HIGHWAY AND LEAD LOCAL FLOOD AUTHORITY RESPONSE TO CONSULTATION ON THE FOLLOWING DEVELOPMENT PROPOSAL

Application number: H14-0640-26

Proposal: Erection of 9 detached bungalows - Approved under H14-0042-24. Modification of Condition 2 to allow amendments to previously approved plans

Location: Land off Crossgate Lane, Pinchbeck, Spalding, PE11 3XW

Client: Melbourne Construction Limited	Drawing Number: M530-56	Revision: B	Drawn by: M C
Project: Residential Development of 9no Dwellings Section 73 Application		Drawing Title: Proposed Site Layout Amended	
Site Location: Land Off Crossgate Lane Pinchbeck.	Date: Aug 2026	Scale: 1:250 @ A1

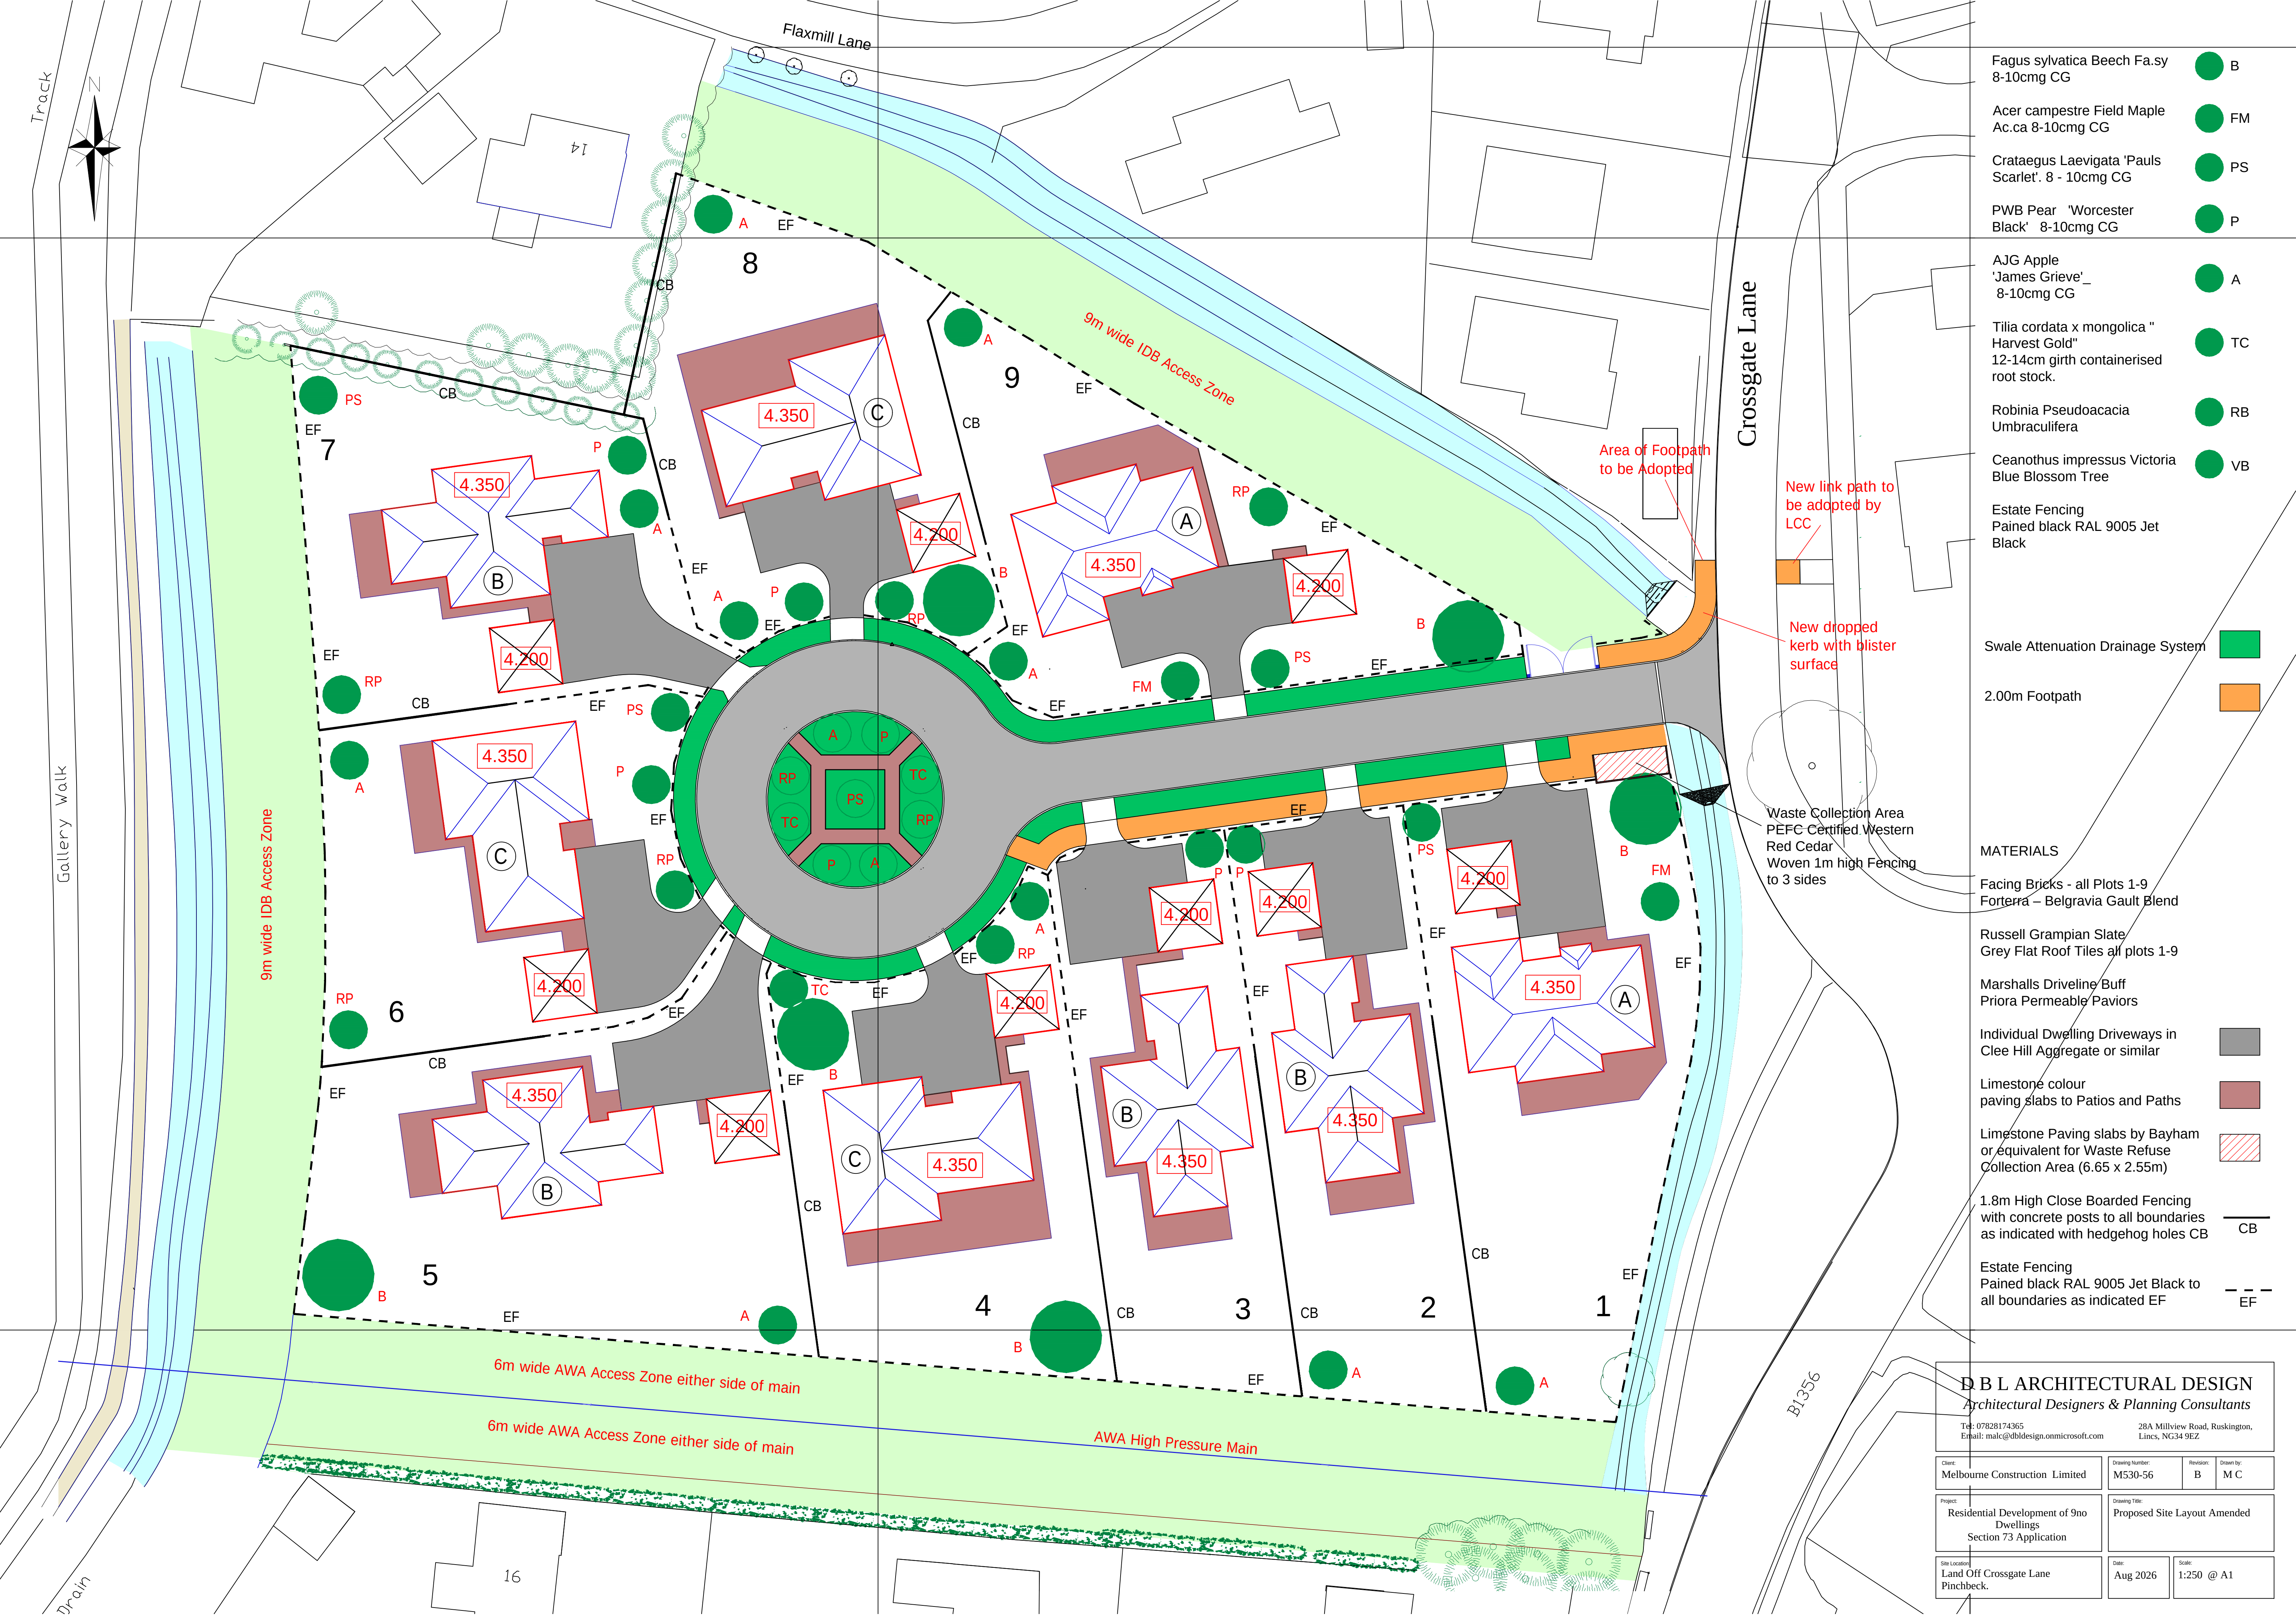
Following the Highway Authority's interim response, revised drawings have been submitted showing a 2m-wide footway connection at the site entrance, an informal pedestrian crossing of Crossgate Lane, details of the replacement culvert, and the extent of the proposed works within the public highway.

It is noted that the revised layout retains a footway along the southern side of the private access road beyond the swale, rather than adopting the shared-surface arrangement previously suggested by the Highway Authority. However, as the internal access road and associated footway will remain private, this is not considered sufficient grounds to object to the variation of Condition 2.
